Please find below my comments and objection to the current submission of Application 2020/62/93954/W 42 houses, Lingards Road .

House Type D1.

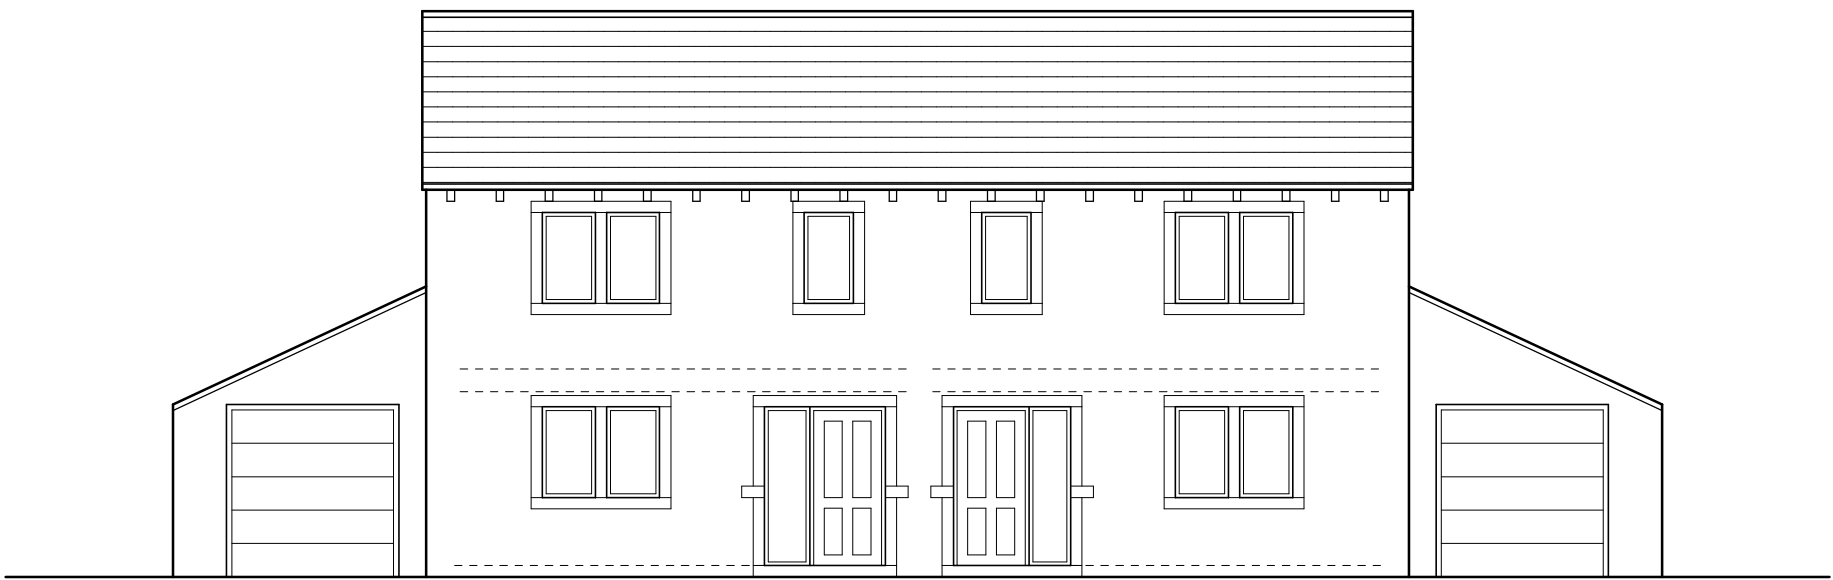
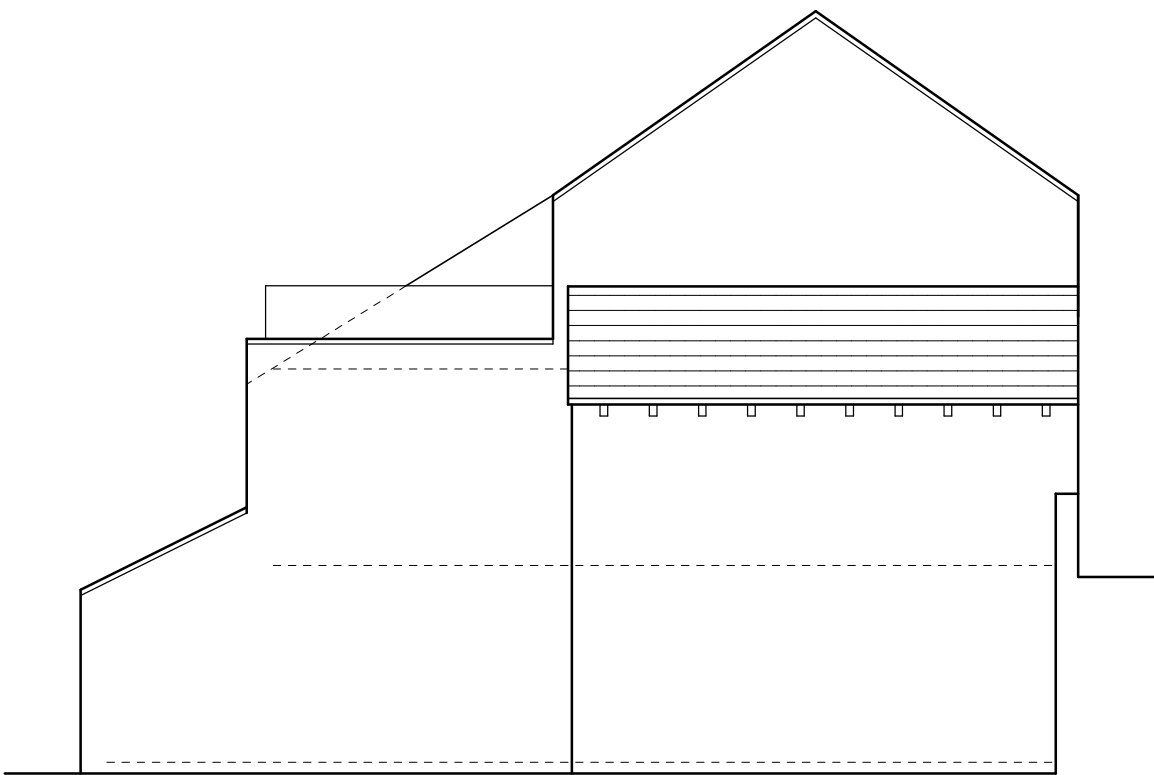
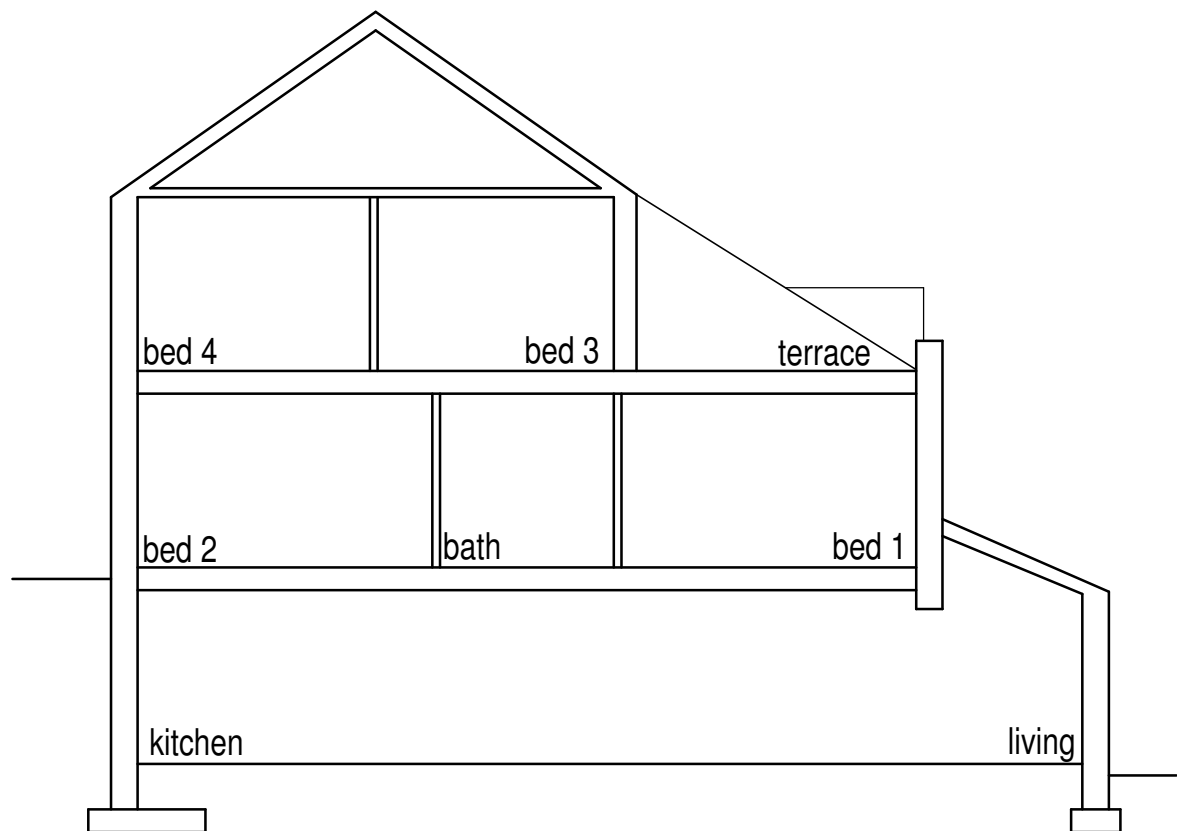
Whilst we appreciate a slight design change in the houses above us, there is still little space between the semi detached blocks (4,5,6 and 7) once hard core retaining walls and garages are built. It was actually the height of the properties that was our major concern previously; we suggested 2 storey houses or bungalows but were told people don't want to buy bungalows. Yet this type of property might have provided much needed housing in the area for those with mobility issues who cannot manage 3 flights of stairs and might be willing to forgo a view.

Heights of houses 1 2 and 3 have been reduced slightly but 4, 5, 6 and 7 are actually higher now and these are directly behind us. They are higher than the SB Homes Fire Station flats in Marsden and they are also on a hill above us, not on a piece of flat land. We will see nothing but these huge buildings towering high into the sky, in fact we won't even see the sky .

The final icing on the cake is that these huge houses stand in a lovely curve (see picture) so that the balconies and sliding doors face directly onto our properties (2 green houses) . I have been asked if we are planning to put on theatre performances for the circle seats from their balconies and large bifold windows . This is no joke, these houses will all be so high that they will look over our rooftops and I do not think we can assume people will not look down. It cannot be said that our privacy will not be affected.
